From: [REDACTED]
To: [Aquind Interconnector; enquiries@beis.gov.uk](mailto:enquiries@beis.gov.uk)
Subject: David Langley's response to letter of SoS on 13th July. Your ref; EN020022
Date: 11 August 2021 20:39:08

David Langley's response to letter of SoS on 13th July. Your ref; EN020022

EN020022-2.11-PARA-Sheet1	Application document reference 2.11 Optical Regeneration Station(s) Parameter Plan Sheet 1 of 1
---------------------------	--

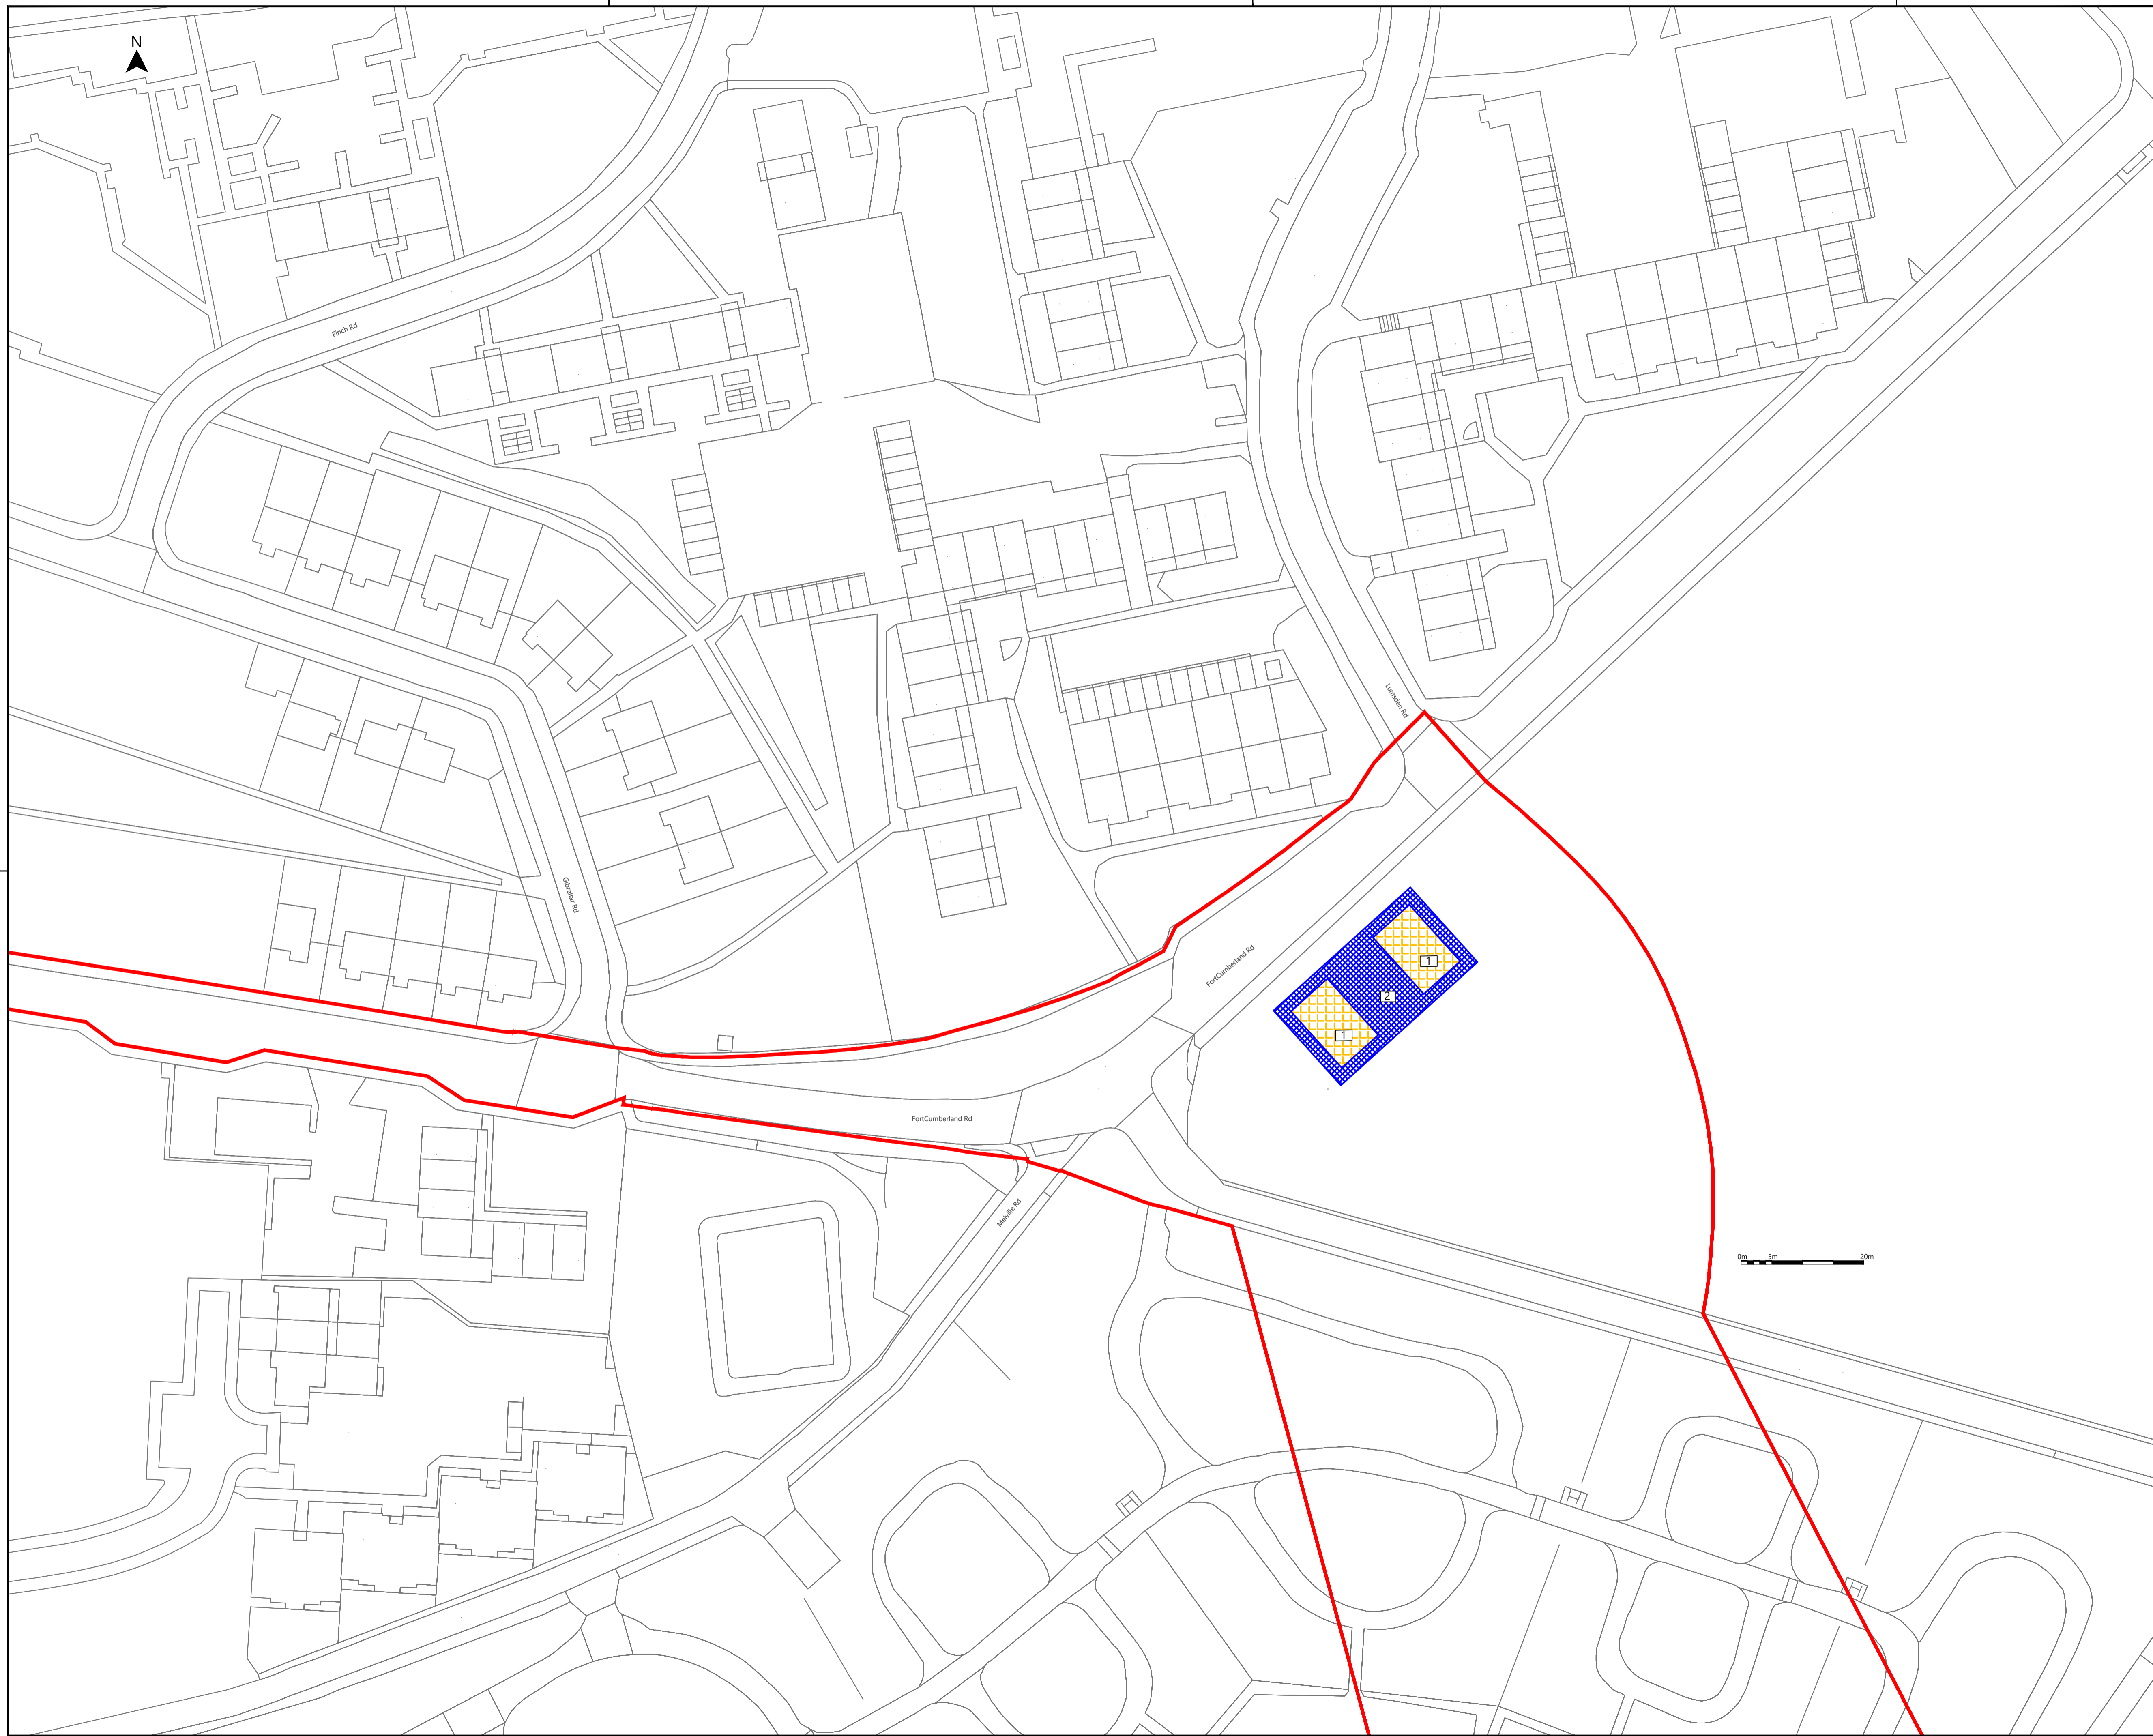
It is clear that ORS are required when the focus is on commercial use of spare capacity, not for normal control and monitoring of the Interconnector. The ORS at Fort Cumberland carpark should not be built at all. It must be removed from the Draft DCO.

Continuing with the theme of ORS, I note that in Aquind's responses to SOS's questions of 13/7/21, they (Aquind) have talked about a reduction of size of the ORS compounds, not the removal of them from the scheme. SoS insisted in his demand that Aquind submit a revised DCO with the commercial element of the FOC removed therefrom. Aquind appear to be toying with the idea that commercial use of spare capacity is not permitted under a NSIP project. At no time is there a clear commitment from them to change the capacity of the FOC. The SoS should insist that the ORS be removed from the landfall site and that an FOC of the correct capacity for control and monitoring purposes only should be installed.
